The Lodge  
1 Armstrong Road  
Littlemore  
OXFORD  
OX4 4XT

25 July 2022

**21/00517/F**

**Creation of a motocross track and soft landscaping scheme and the change of use of agricultural land to hold moto-cross events including set-up, take down and private practice sessions, with associated camping site, for up to 65 days per year and agricultural grazing (retrospective).**

Figure 31 Recommended sediment control measures, along the track's north eastern margin

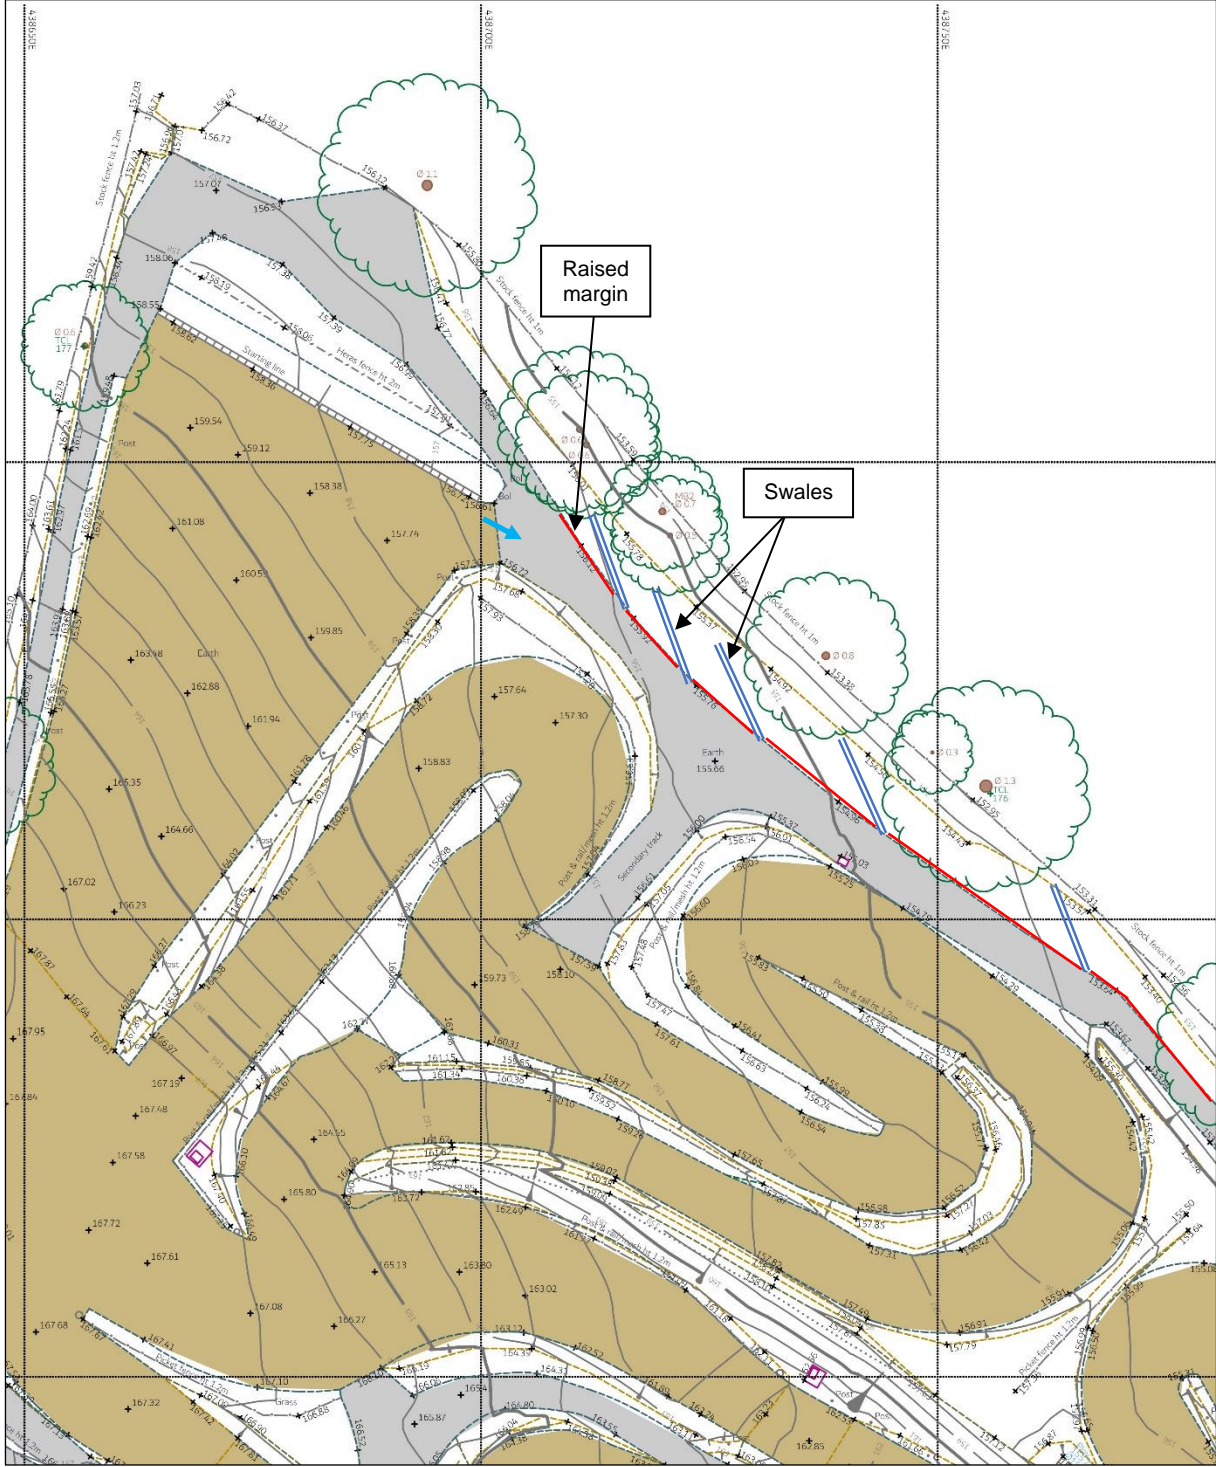
We note that paragraph 5.12 of the DAS states: *“5.12 The FRA report also considers surface water run-off and confirms that the drainage system across the track was designed to manage runoff and the high sediment loads within it. The upper or “silt” pond is cleaned out every three years and sediment is spread back on to the track. Additional structures have been recommended to manage*

*sediment discharge in the western part of the track, associated with the starting grid. A series of short swales, aligned parallel with the contours are suggested to trap sediment.”*

*“5.13 The Ecological Appraisal from Chris Seabridge and Associates Ltd and the Flood Risk Assessment (Lidar Logic 2021) both identify the potential for surface water runoff at the site. The Flood Risk Assessment has identified the measures that can be taken by the applicant to reduce this risk, to accord with both national and local plan policies. Please refer to the FRA, at Figure 31, ‘Recommended sediment control measures, along the track’s north eastern margin’ for details.”*

The measures described in these two paragraphs (and in the accompanying documents they refer to) are of great importance, however the use of phrases such as “have been recommended” and “has identified” (e.g. as opposed to “will take place” or similar) do not give sufficient surety to ensure that all these measures will be both put in place, and maintained for the duration of the existence of the motocross site. We would ask that conditions or otherwise are used to ensure that all the above measures are put in place, and maintained for the duration.
